City of Albuquerque Stormwater Construction Site Inspection Report

ESC File No.	A12E008B1	Project Name:	Golf Course and Westside Blvd - Circle K		
NPDES Id. No.	NMR10074M	Location:	10850 Golf Course Rd NW		
11/19/2025	Owner	Contractor			
Operator	Circle K Stores Inc.	Black Canyon Construction			
Contact name & title	Mark Tate	Logan Green			
e-mail	<a href="mailto:mtate@circlek.com">mtate@circlek.com</a>	<a href="mailto:logan@bcanyon.com">logan@bcanyon.com</a>			
Contact Phone #	303-903-1116	830-331-7440			
COA Inspector	Chancellor English	Start/End Time:	11am		
Construction Phase:	Utilities, landscaping, interiors				
Type of Inspection:	Regular	Storm Event	Post Storm Event >0.25"	311/Complaint	Follow Up
Weather at time of inspection?	Cloudy	Temperature:	~	55	
Estimated date of last storm 0.25" or greater	10/14/2025

EC02

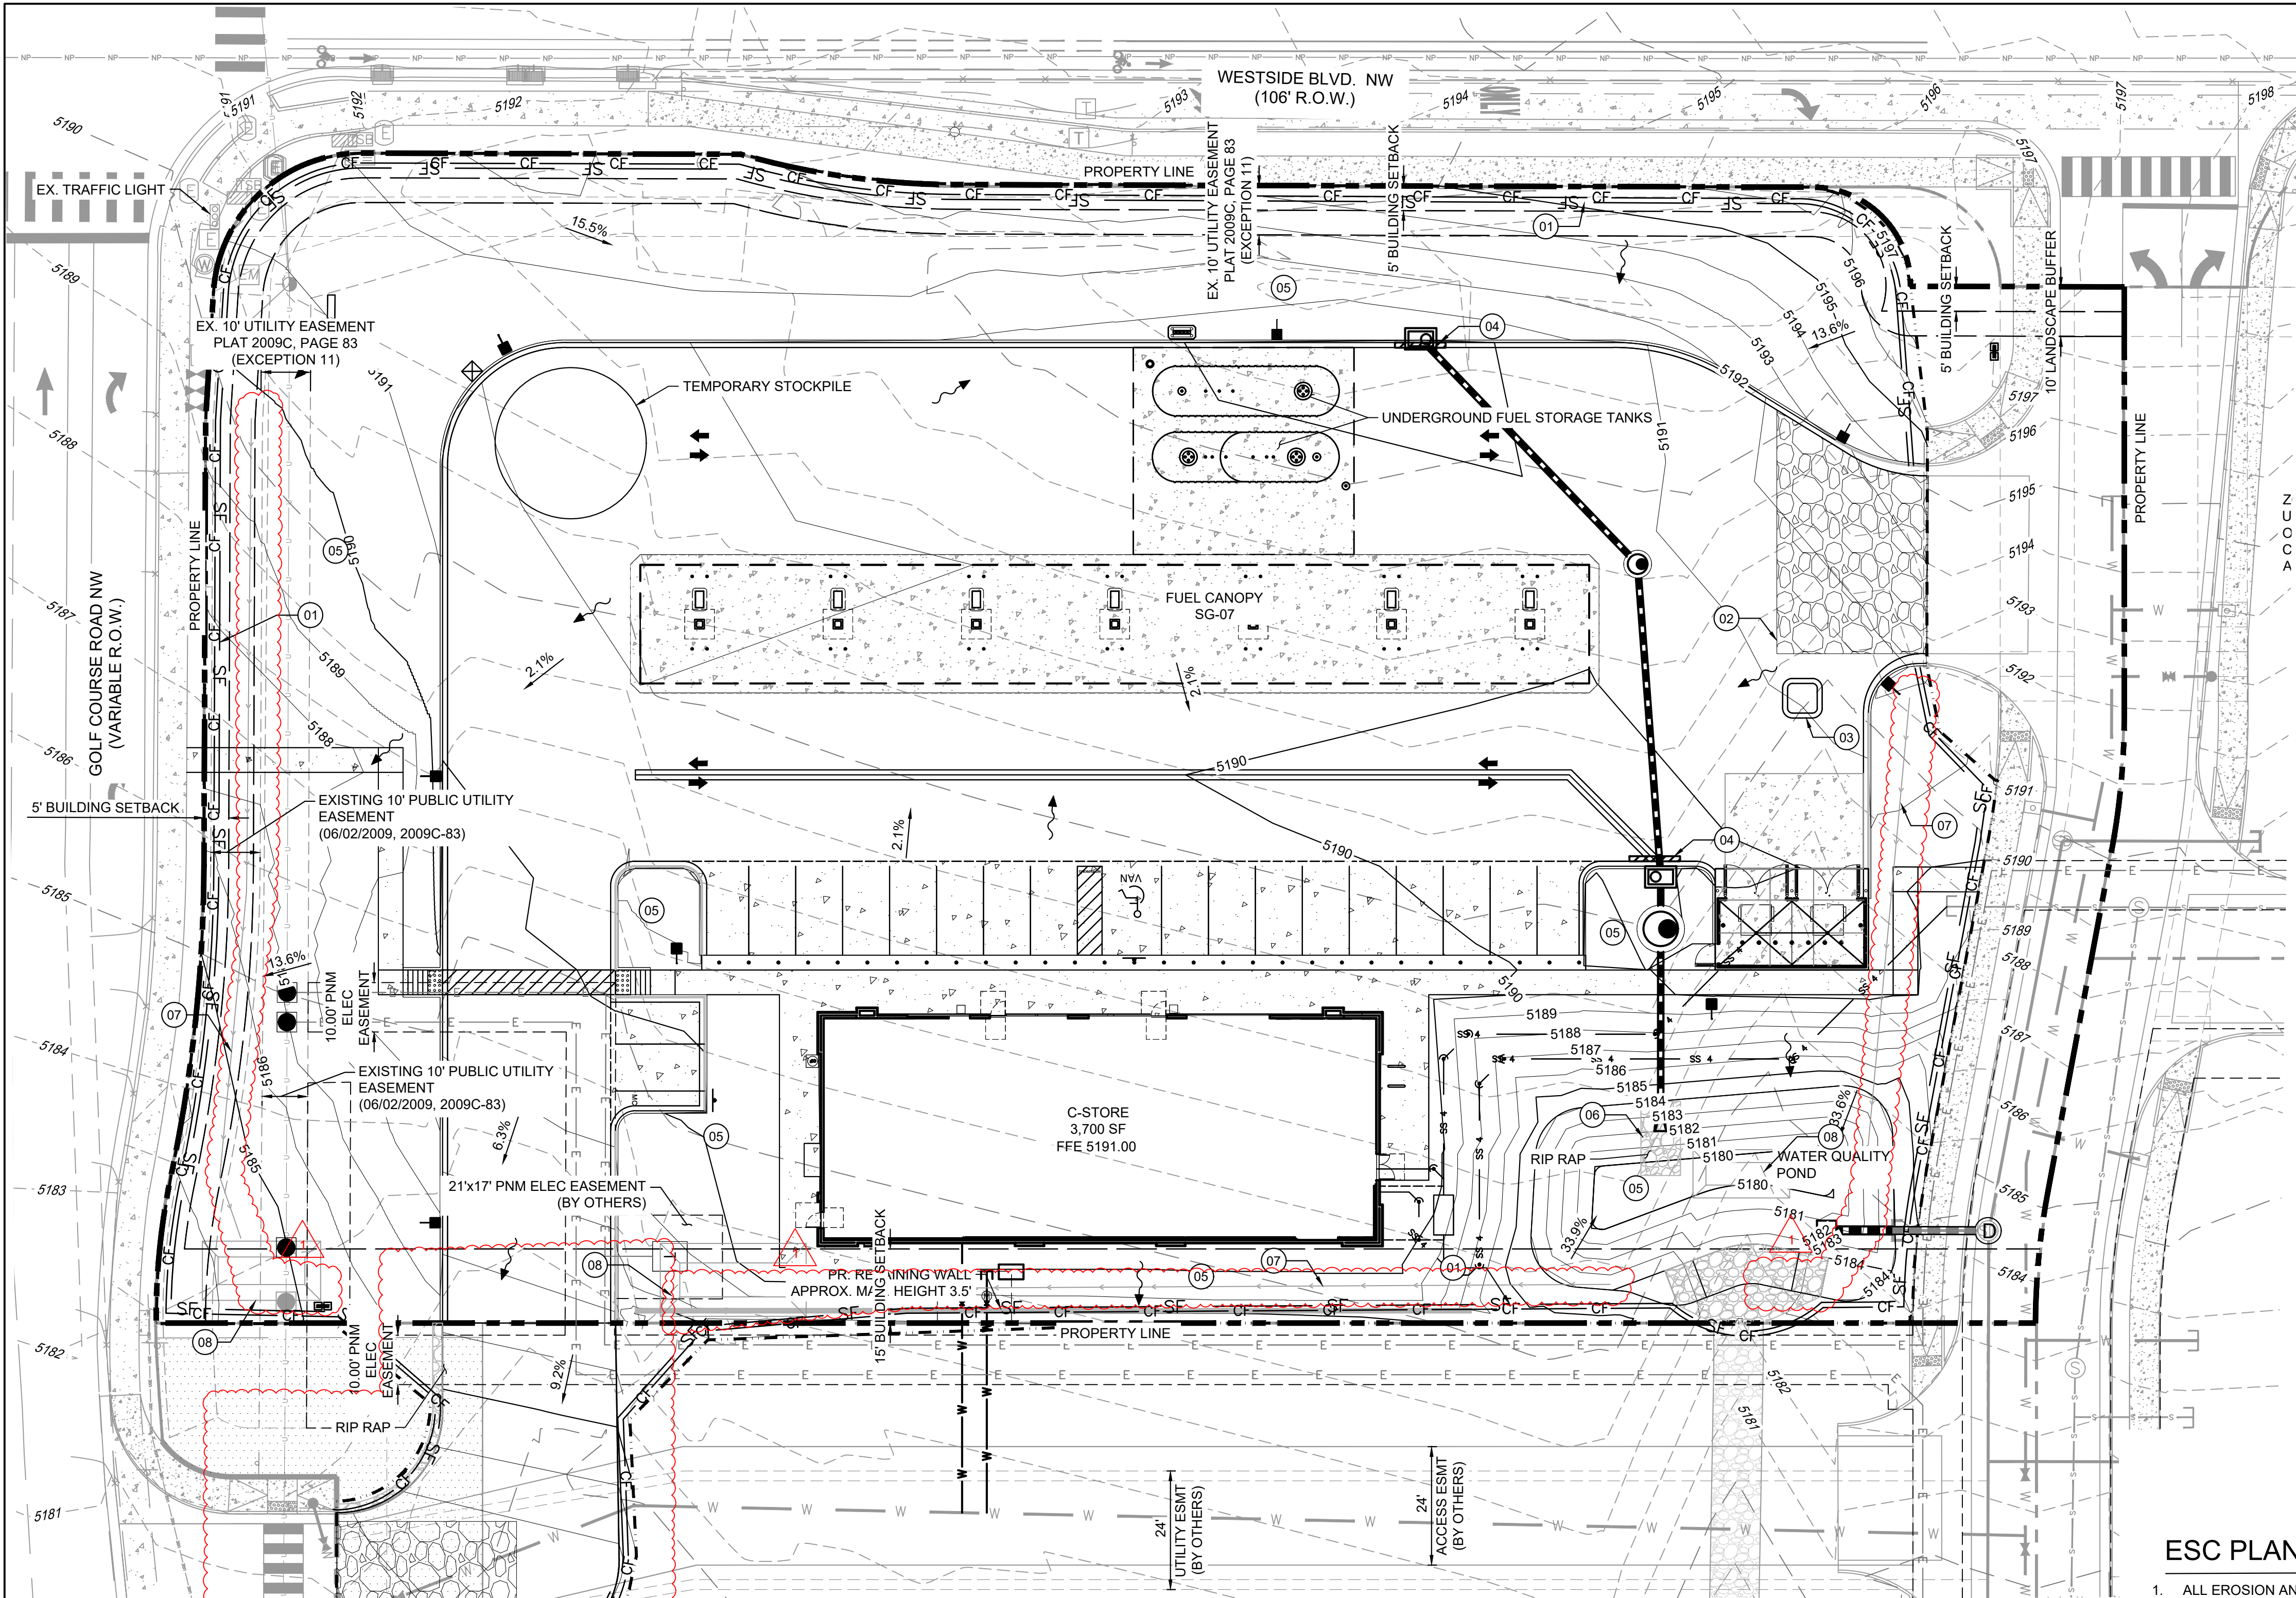
Item Number	Deficiency/ Corrective Action				
1	<p>SWPPP - The SWPPP is not certified by all operators in violation of CGP Part 7.2.10. The map included in the SWPPP does not match the City-approved ESC Plan that utilizes sediment traps/ponds in violation of CGP Part 7.4.1. There are construction support activities on neighboring property and stormwater controls not marked on the SWPPP map in violation of CGP Part 7.2.4. The construction exit onto Golf Course Rd is not installed with Best Engineering Practices in violation of CGP Part 2.1.2. The self-inspection reports were not available for review during the inspection in violation of CGP Part 4.7.3. <b>Required mitigation:</b> Your signatory must sign and date your SWPPP in accordance with CGP Appendix G, Part G.11. You must modify your SWPPP, including the site map(s), within 7 days to reflect any revisions to applicable Federal, State, Tribal, or <i>local</i> requirements that affect the stormwater controls implemented at the site per CGP Part 7.4.1.e. Include a legible map, or series of maps, showing locations of on-site and off-site construction support activity areas per CGP Part 7.2.4.b.vii. Design and install all stormwater controls in accordance to good engineering practices, including applicable design specifications per CGP Part 2.1.2. You must keep a copy of all inspection reports at the site or at an easily accessible location so they can be made immediately available at the time of an on-site inspection per CGP Part 4.7.3.</p>

Concrete washout is leaking from the washout container. A poorly installed construction exit onto Golf Course Rd. A rejected ESC Plan was used during construction, not the approved ESC Plan showing temporary sediment traps as stormwater controls during the construction process. Stockpiles, parking, and a washout container located on neighboring property that are not identified in the SWPPP.
